Flide Street, Caringbah, Affordable
Housing

SSD-84862461

Submissions Report

Prepared For: Homes NSW

Drawing Title  
**DA01 - Site  
Proposed Site Plan**

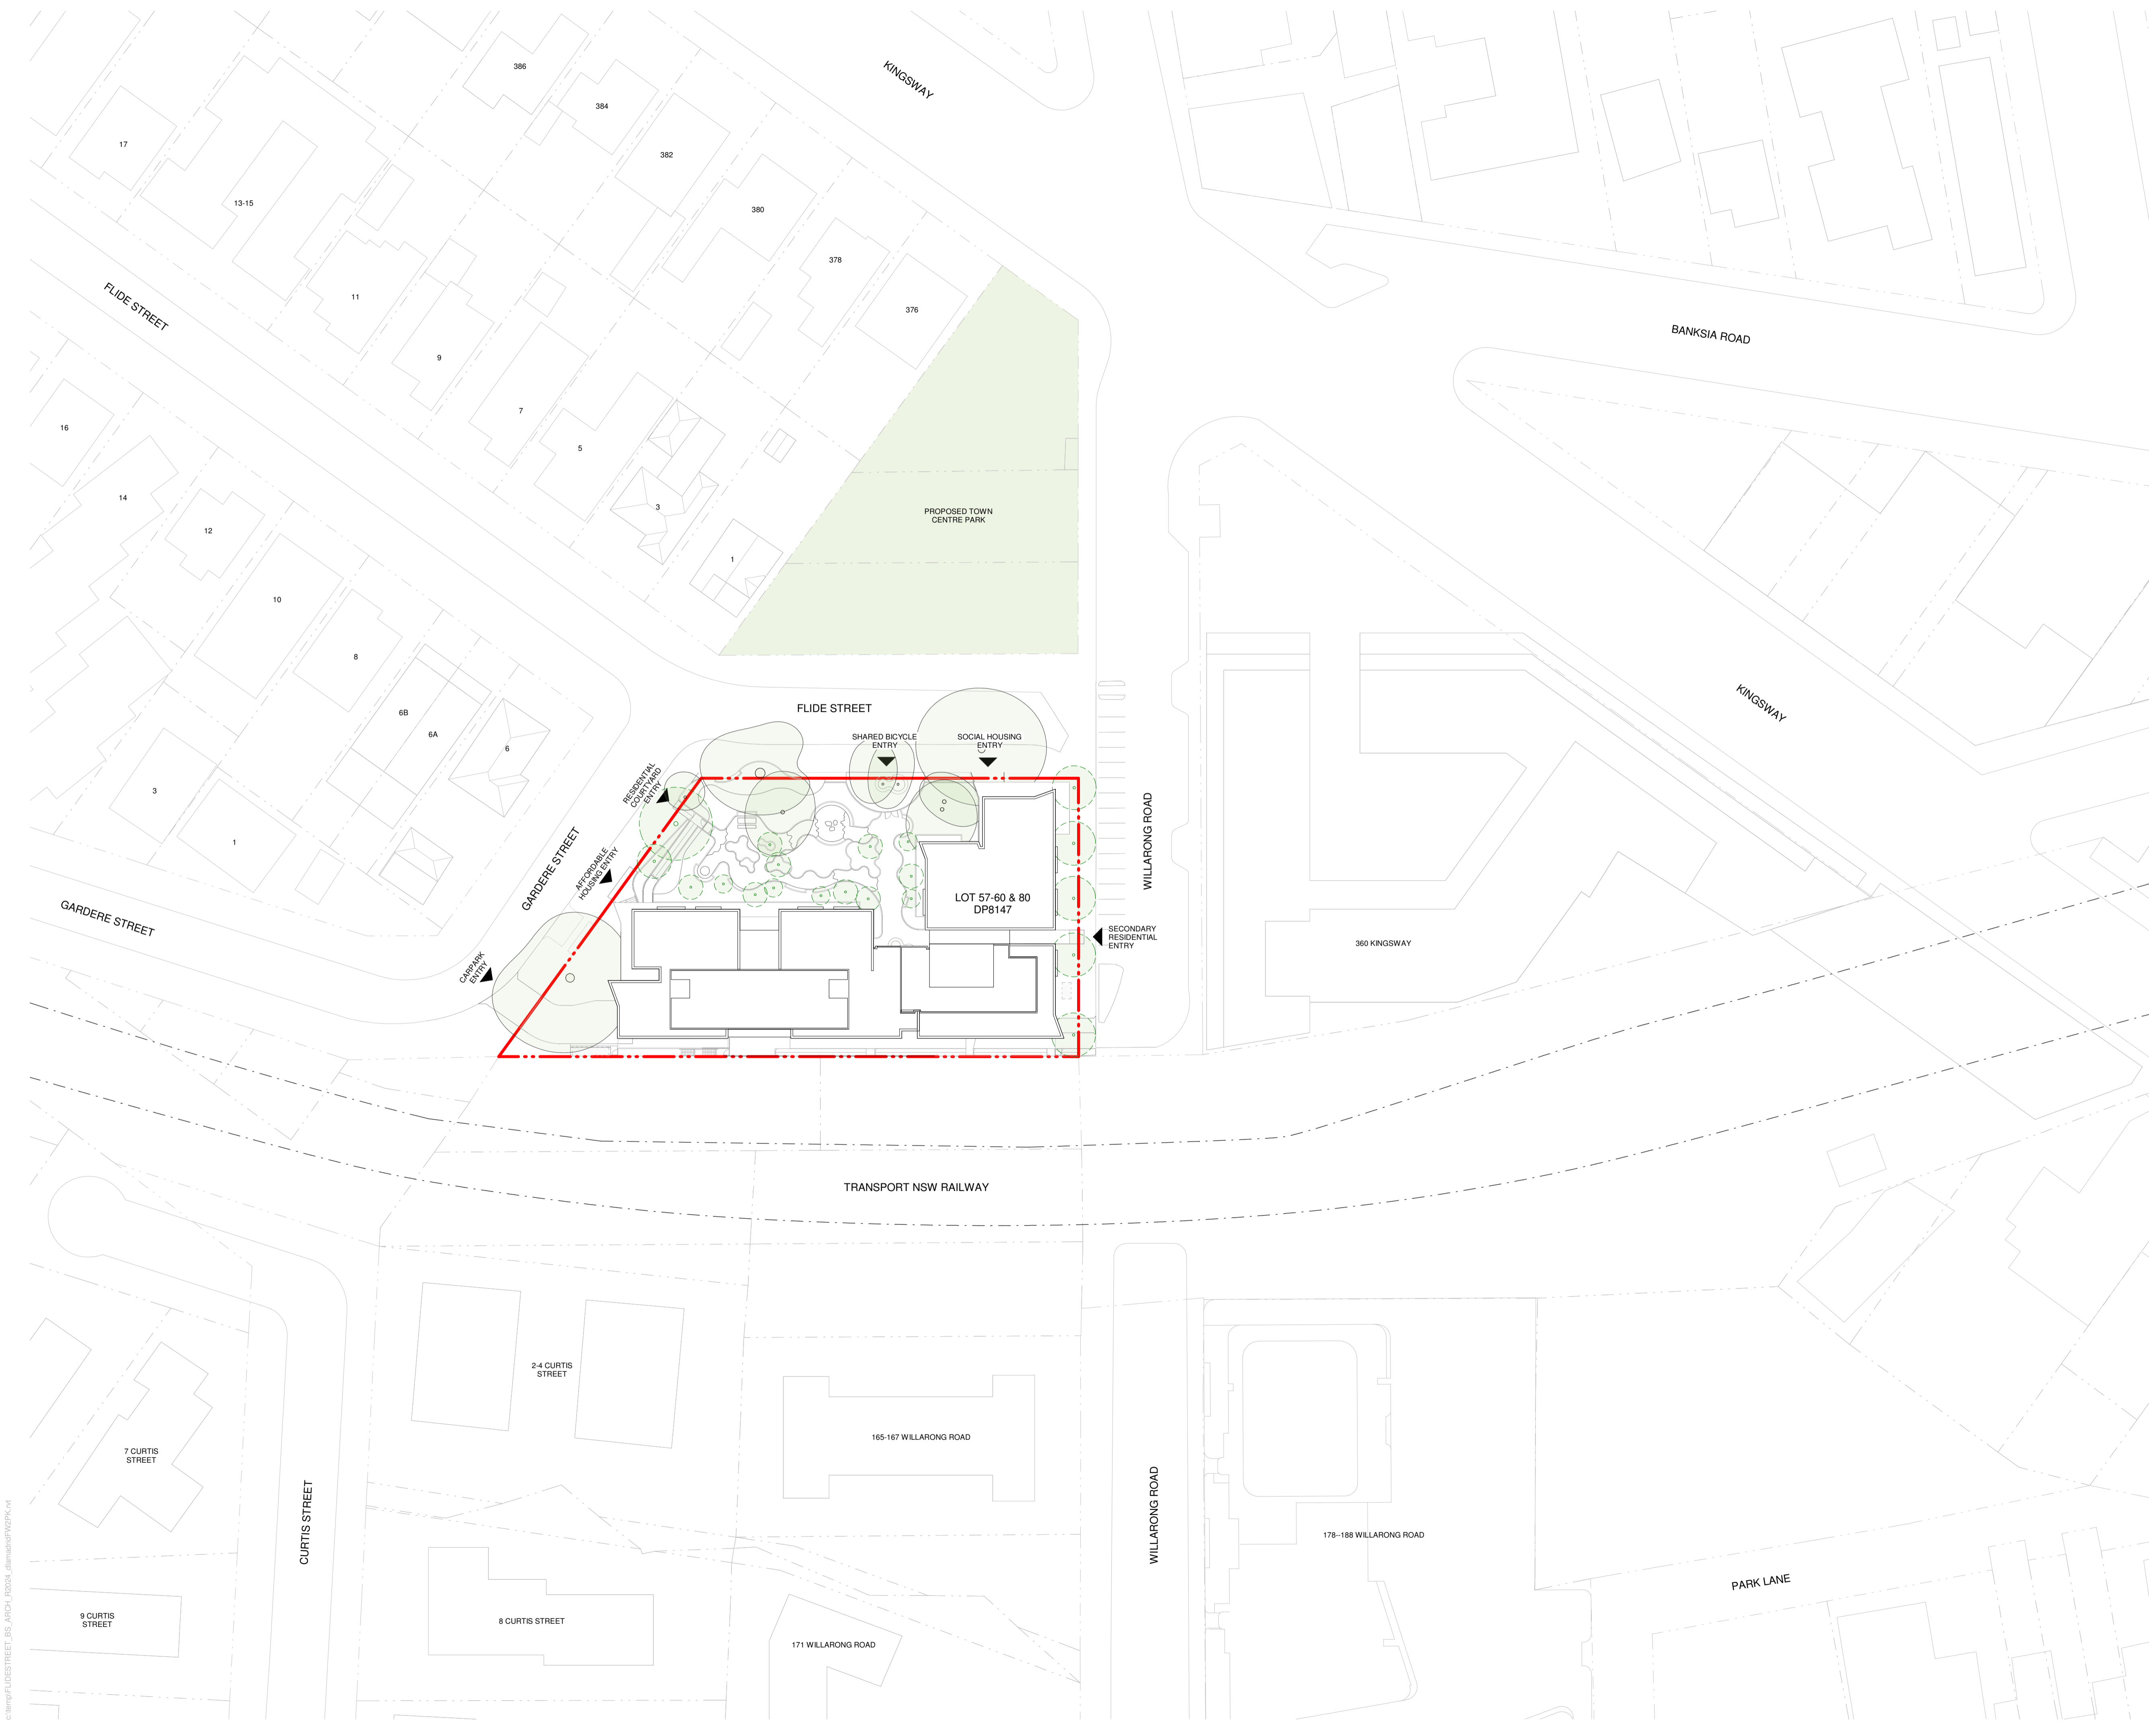
Submission Reference	Matters Raised	Response
Rezoning		
DPHI_01	The height sought under the proposed rezoning would result in overshadowing impacts, particularly to podium units of 360 Kingsway (Meriton). Please provide comparative analysis illustrating the extent of overshadowing from a compliant design.	Shadows of compliant vs proposed building envelope has been undertaken by Bates Smart in Appendix C. Further assessment is provided in Section 4.5.
Traffic and Access		
DPHI_02	Amend the proposal to direct all vehicle access via the Willarong Road cul-de-sac, which connects to a signalised intersection at The Kingsway/Willarong Road, allowing for all movements under signal control If an alternative access arrangement is proposed, please consult with Transport for NSW (TfNSW) to address concerns regarding cumulative traffic impacts and road safety.	The proposal has been amended to direct all vehicle access via the Willarong Road/ The Kingsway intersection as requested. This arrangement is further considered in Section 4.5.1 and TTPP's Transport Impact Assessment at Appendix E. No alternate access arrangements are proposed.

Submission Reference	Matters Raised	Response
	- Removal of the road island in Willarong Road to enable access to waste store. - Review the driveway design to ensure retention of the existing large eucalypt tree adjoining. - Booster location will need to be reconsidered in consultation with fire services.	
Pedestrian Access & Ground Level Apartments		
SSC_06	- Given the future closure of Flide Street consideration should be given for the social housing entrance to be provided off Willarong Road. - Consider the provision of individual access points to ground level units to provide a domestic scale and quality to the development. - Site ground level apartments so they sit above grade, with a landscaped terracing to provide both privacy to occupants and surveillance of the streets and open space. Avoid use of full floor to ceiling glass. This can result in blinds being pulled throughout the day and night. - The secondary pedestrian access on Willarong Road is recessed into the building and may cause safety concerns, it is recommended that the glass line is brought forward.	The basement driveway entry has been relocated to Willarong Road. Consequential design changes include the reconfiguration of proposed waste servicing to Willarong Road and the removal of the secondary pedestrian entrance. As a result of these changes, there are no longer suitable options to provide a residential entry from Willarong Road as detailed at Section 3.2.1. The privacy and amenity of ground level apartments have been carefully considered. Ground level apartments fronting Willarong Road are set approximately 1.5m above street level and are further screened by canopy trees within the setback to ensure privacy while maintaining passive surveillance. Apartments fronting the communal open space incorporate privacy screens to balconies, generous landscaped buffers and subtle level changes ranging between 0.1m and 0.4 metres to reinforce separation between private and communal areas. The design approach avoids extensive floor-to-ceiling glazing at ground level and instead balances privacy, surveillance and residential amenity through built form modulation, landscaping and considered glazing treatment. These measures collectively provide a domestic scale, appropriate privacy outcomes and a high-quality residential interface to the street and communal open space.

Drawing Title  
DA21 - Compliance  
Cross Ventilation

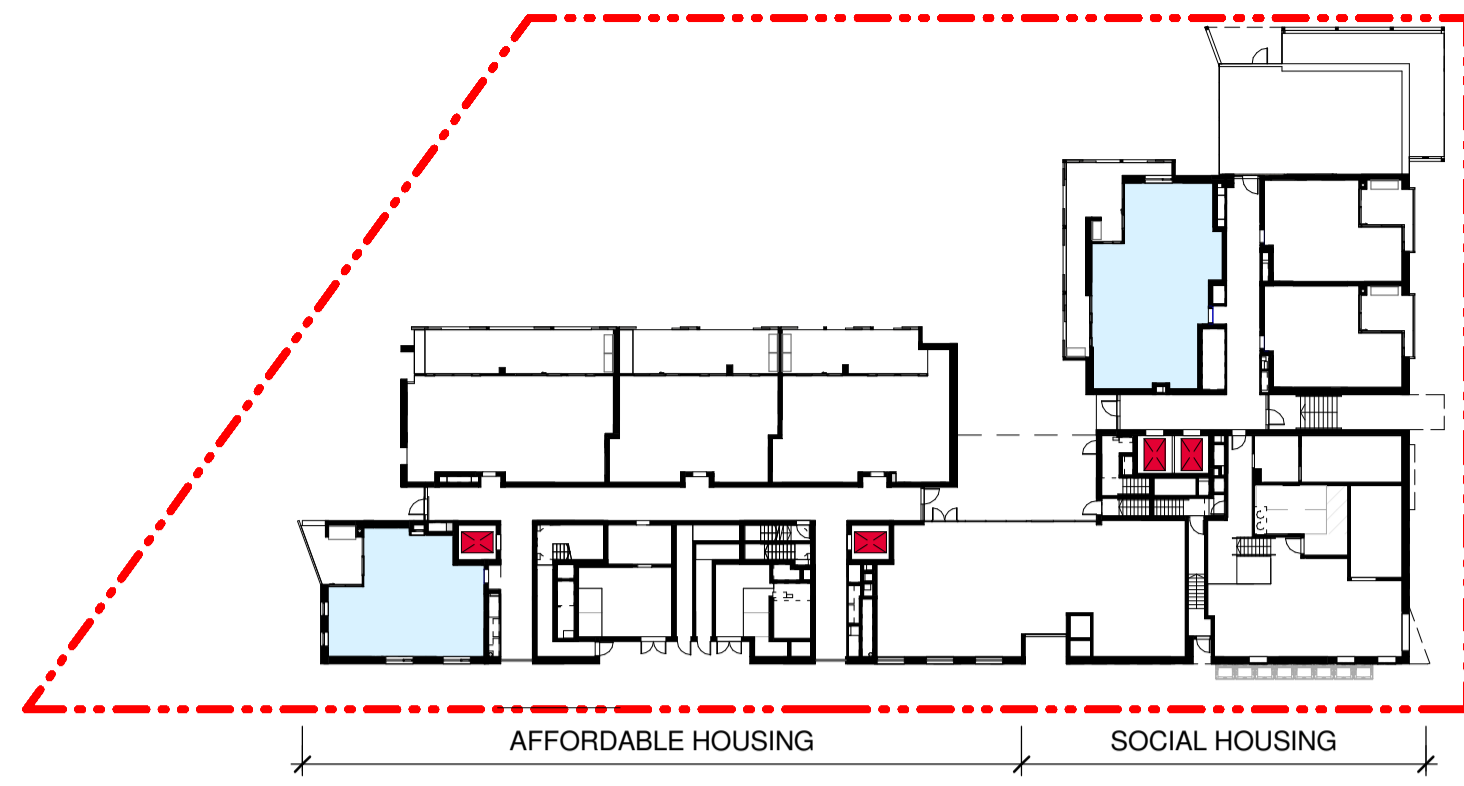
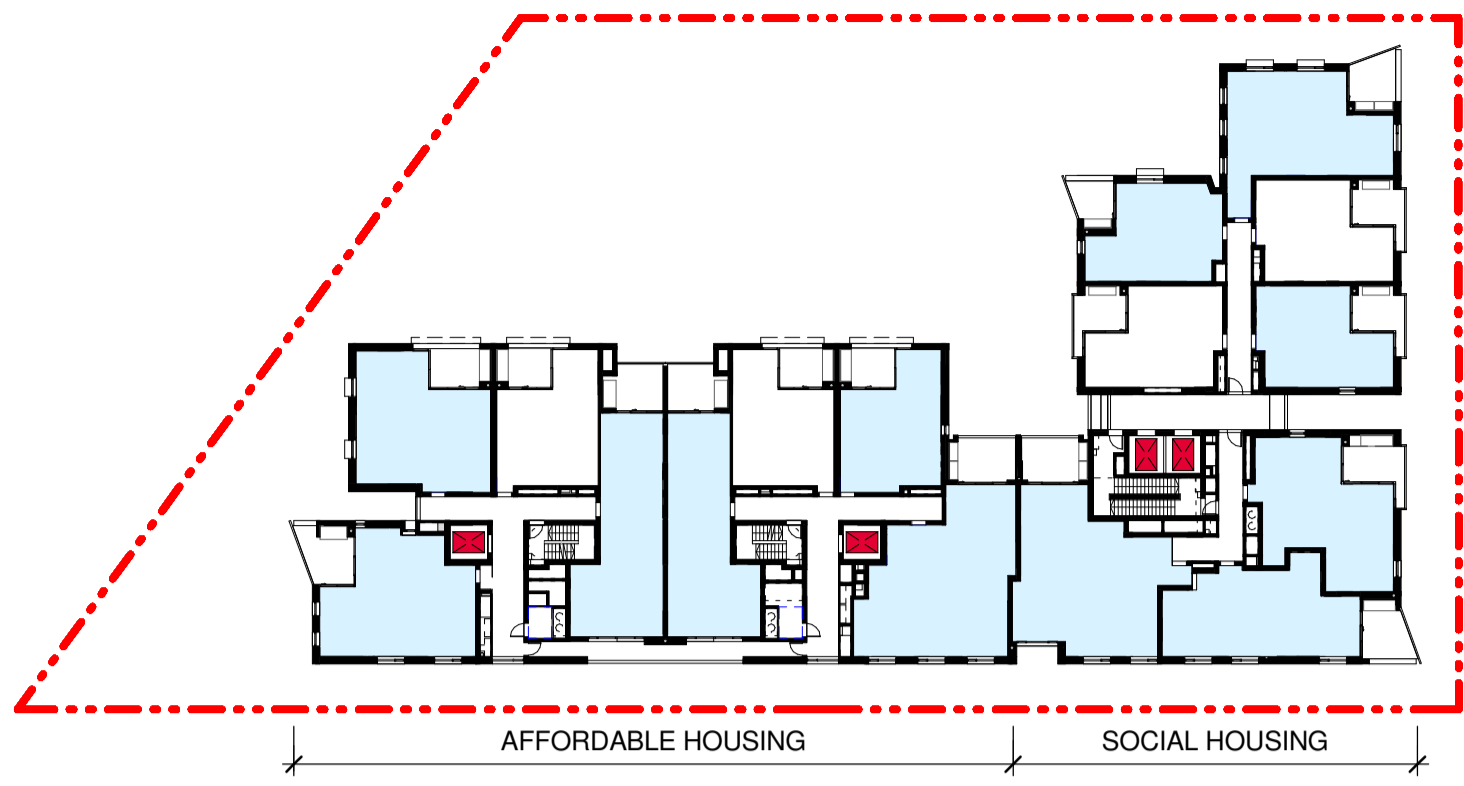
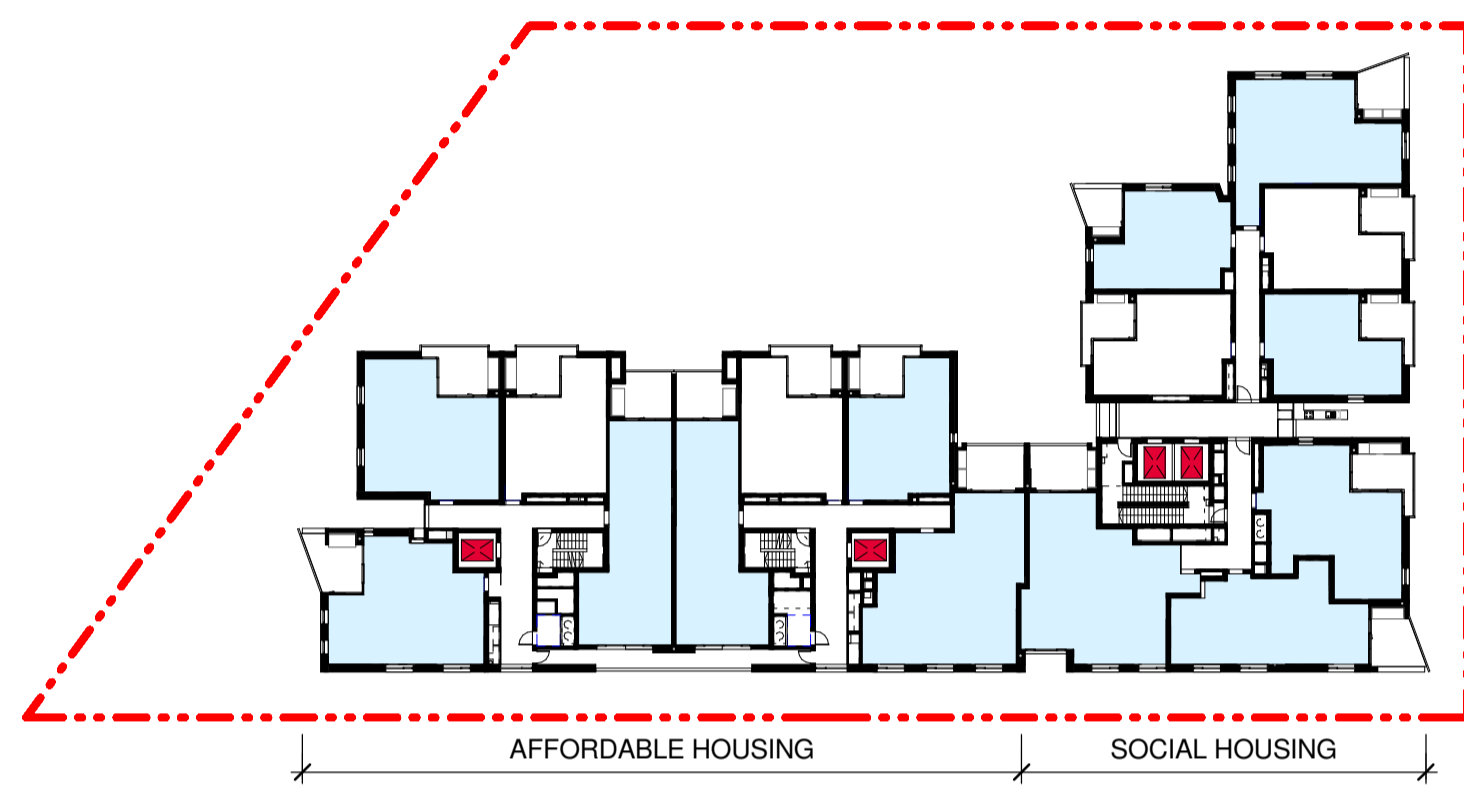
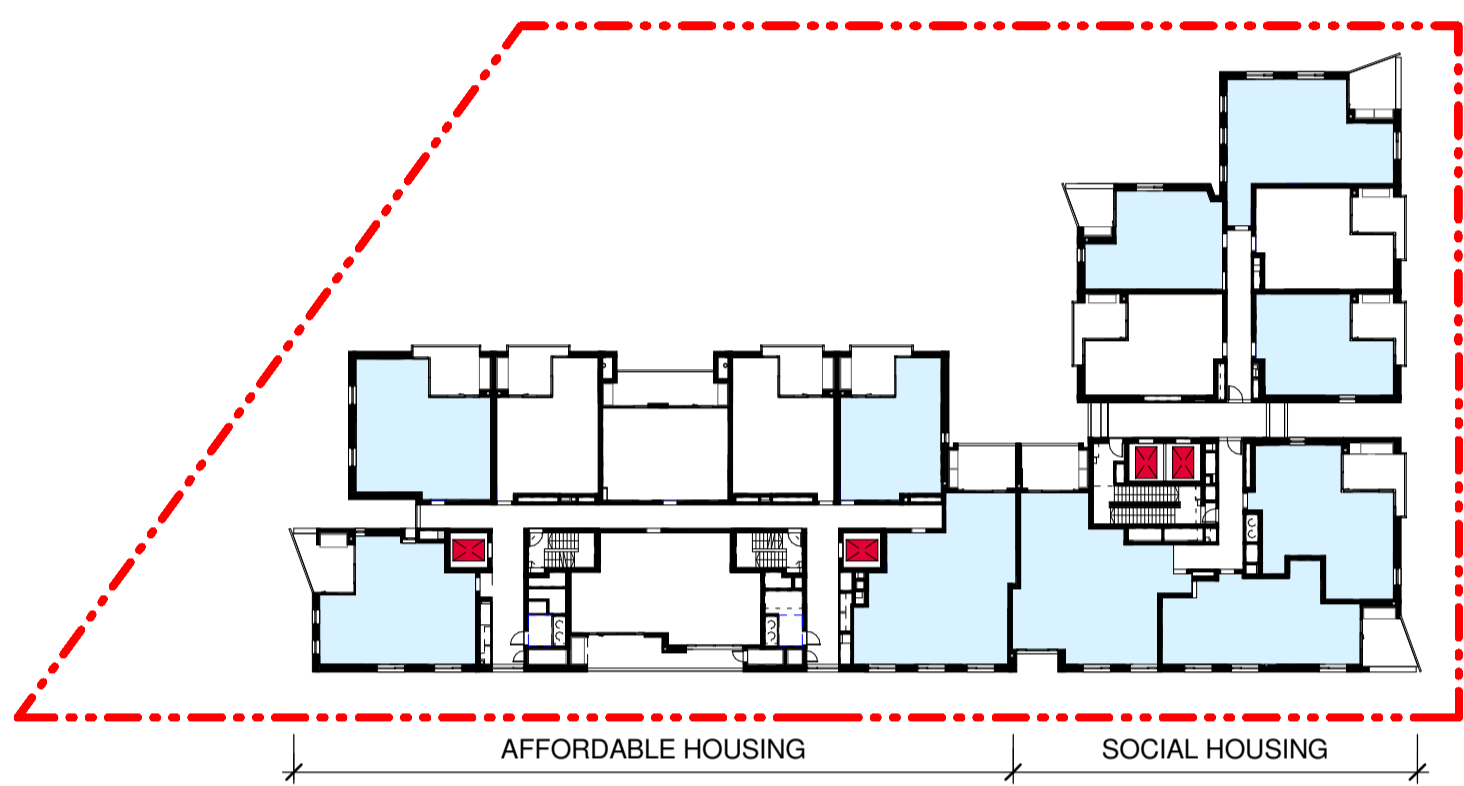
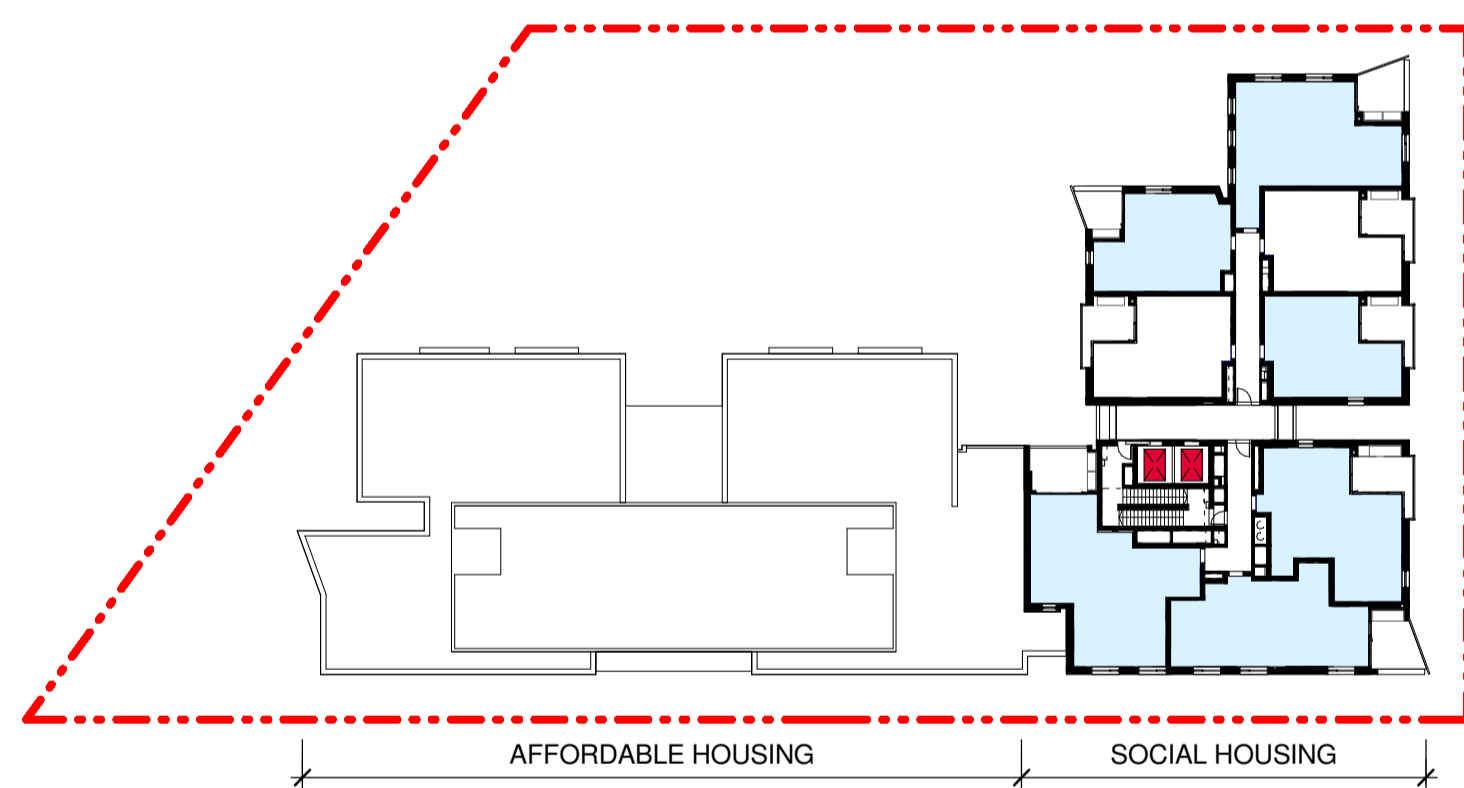
DPHI_06	Amend the ventilation diagrams to demonstrate wind access. Where feasible, incorporate vertical plenums to support natural ventilation, particularly in response to the site's acoustic constraints.	The Noise and Vibration Impact Assessment (EIS Appendix AA) notes that Clause 2.1 of the SEPP Transport and Infrastructure 2021 has been considered, as well as 3.6.1 of the DoP Interim Guideline, and concludes that: • The adopted noise criteria can be achieved through the selection of glazing and a sealed façade and • Internal noise levels will comply with windows open. Therefore, vertical plenums are not necessary.

Submission Reference	Matters Raised	Response
SSC_07	Design materials are supported and provide sustainable design quality & articulation. There is a lack of genuine cross ventilation – apartments require redesign or amalgamation to enable this to occur. The consideration of vertical plenums within the development to avoid train and road noise. This allows for for natural ventilation in noisy environments without the need to open a window.	Noted. Cross ventilation diagrams have been updated and demonstrates compliance with the ADG at Appendix C. Internal noise levels will comply with windows open. Refer to Submission Reference DPHI_06.
Waste Collection		
SSC_08	Request for all bin rooms to have double doors to accommodate the movement of 660L bins.	This has been updated. Refer to Appendix A.
Landscape		
SSC_09	The path along the southern boundary should be reviewed and provided against the building to allow for more substantive plantings at the boundary of the rail corridor and needed visual landscape relief to the building. An intermix of the following variety of native tree species in the southern landscape strip is encouraged to achieve above and to contribute to biodiversity. • <i>Eucalyptus Punctata</i> Grey Gum, • <i>Allocasuarina littoralis</i> (Black She-Oak), • <i>Allocasuarina torulosa</i> (Forest Oak) • <i>Eucalyptus globoidea</i> (White Stringybark)	Refer to Submission Reference DPHI_09. The tree planting schedule at Appendix B includes a variety of native trees selected to complement the existing street trees and enhance the biodiversity of the Site. These have been selected in accordance with Homes NSW Resilient Landscape Guide which requires trees that are low maintenance, drought tolerant, and appropriately scaled and sited for the application. The Arboricultural Impact Assessment prepared by Arterra at Appendix D has assessed the impact of the proposed development on existing trees to be retained including consideration of retaining walls, solid walls and site levels. Recommendations by Arterra to ensure the retention and protection of these trees are included within the mitigation measures outlined in Appendix Y of the EIS and will be implemented throughout construction.
